An
Bord
Pleanála

Inspector's Report ABP-318683-23

| Development | Demolition of all existing waste processing buildings on site and construction of a new modernised multi-processing facility. |
| Location | Panda Waste, Ballymount Road Upper, Ballymount, Dublin 24 |

VISIBILITY SIGHTLINES AT ENTRANCE SCALE 1:250

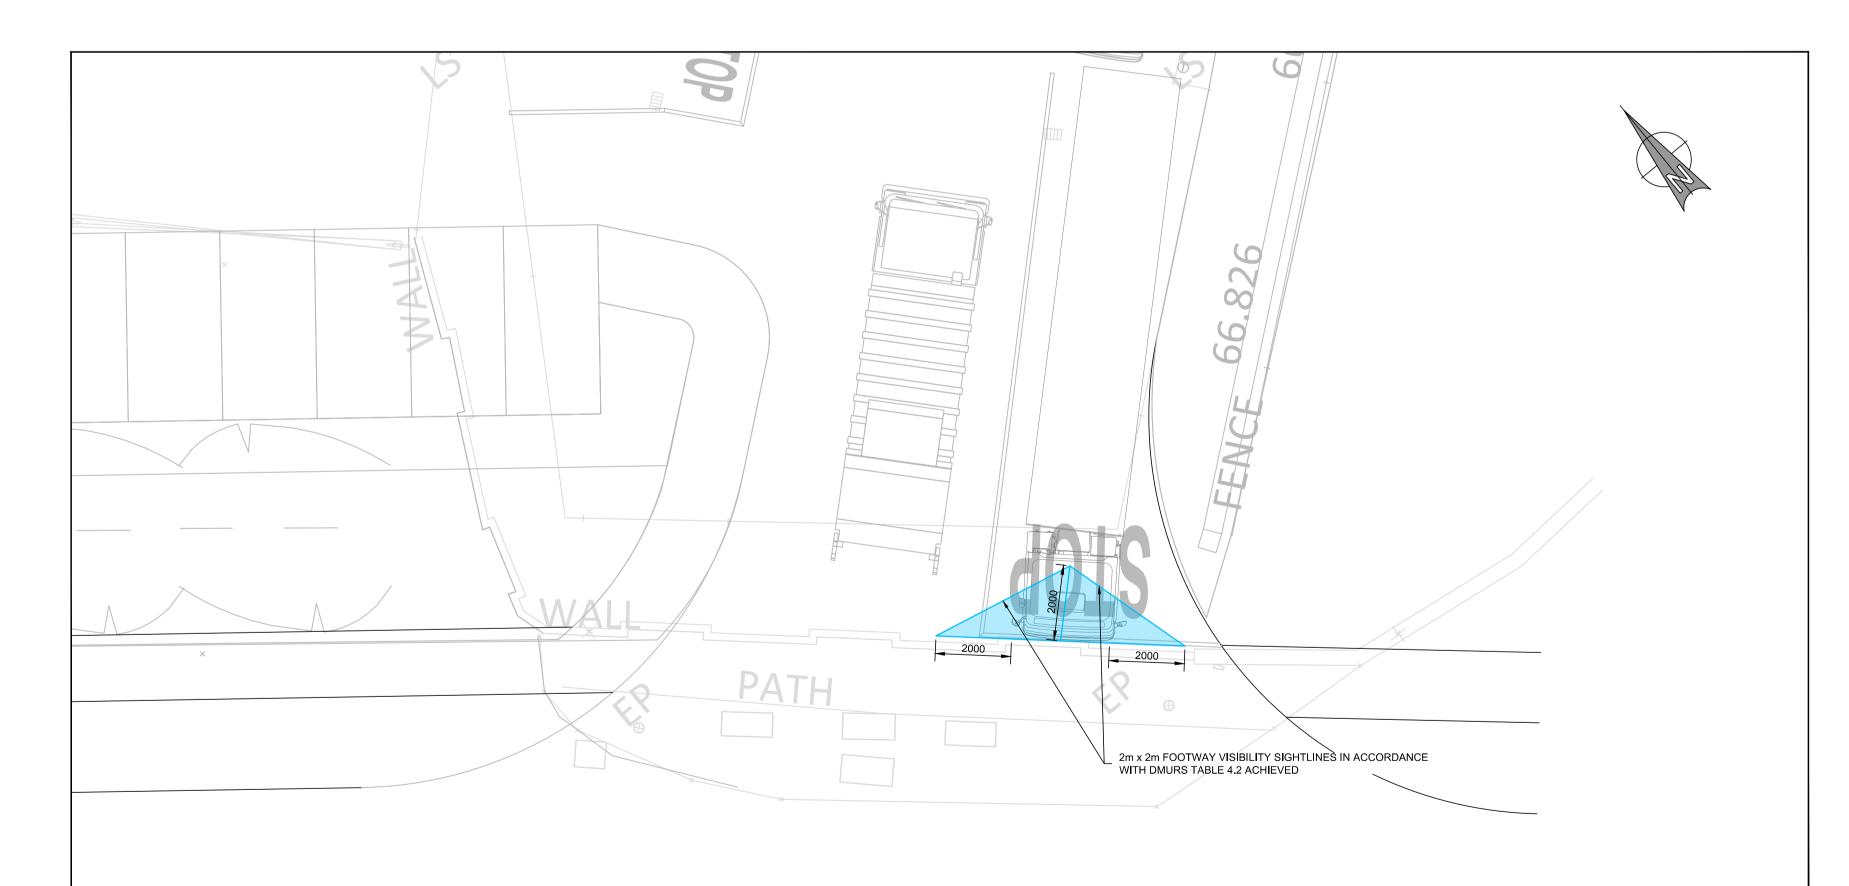
- The Roads Department make the following comments:
 - Noting the separation of vehicular and pedestrian/cycle access and stating that sightlines at the vehicle access point are acceptable.

- Consider the width of the access to be excessive but notes that the autotrack details the HGVs using the entire width. A pedestrian crossing requires a footpath on both sides of the access.

- It has no objection, subject to conditions including: pedestrian footpaths to be provided either side of vehicular entrance, submittal of a Stage 1 Road Safety Audit and reduction of car parking.
